Martins Creek Quarry Expansion – Application No SSD-14_6612

3. We write to oppose in its current form the State Significant development application by Buttai Gravel Pty Ltd (Daracon – the proponent) and its accompanying Environmental Impact Statement (EIS) prepared by the proponent and exhibited between 13th October and 24th November 2016. In particular, we set out in our submission below a number of concerns which we have with the EIS and request that relevant principles of case law be adopted in the decision making process.

Drawing Title
MARTINS CREEK QUARRY
DUKE STREET / KING STREET, PATERSON -
INTERSECTION MEDIAN WORKS

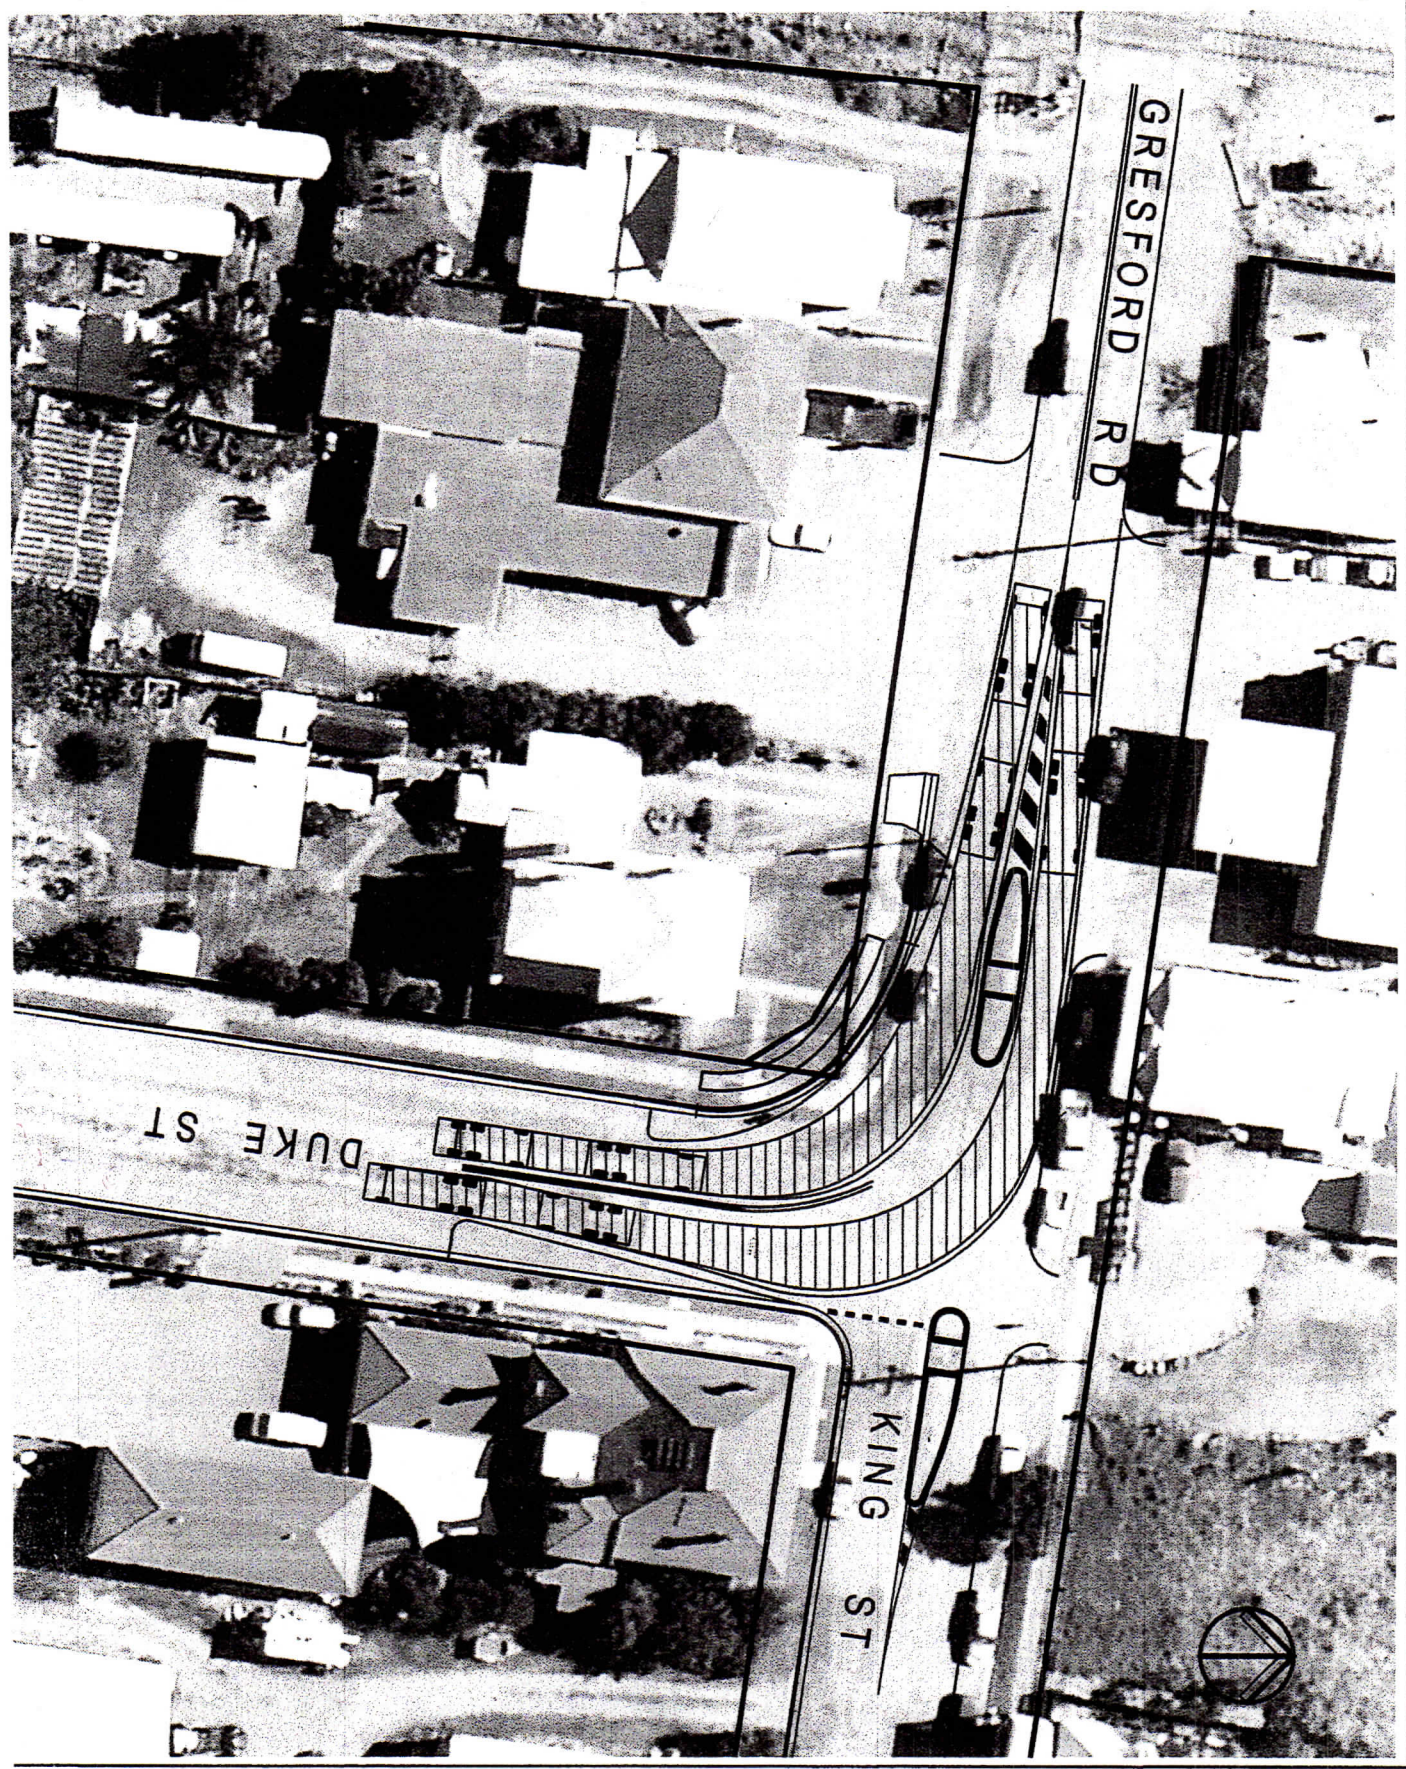
- Appendix 7 Road Condition & TIA Photos Photo 3: No consideration has been provided to the safety issues generated by traffic entering King St from Church St. This turn is utilized by local residents but also by road users accessing and egressing from both Paterson Primary School, Paterson Historical Rail Society, St Columbas Catholic Church, Paterson Court House and Paterson sports ground area. Vehicles entering King St from Church St are required to enter with a reduced sight line to the north. Conversely the South bound right hand turn from King St in to Church St has no sheltered turning lane. The safety issues relating to this intersection have not been addressed or considered in the current TIA
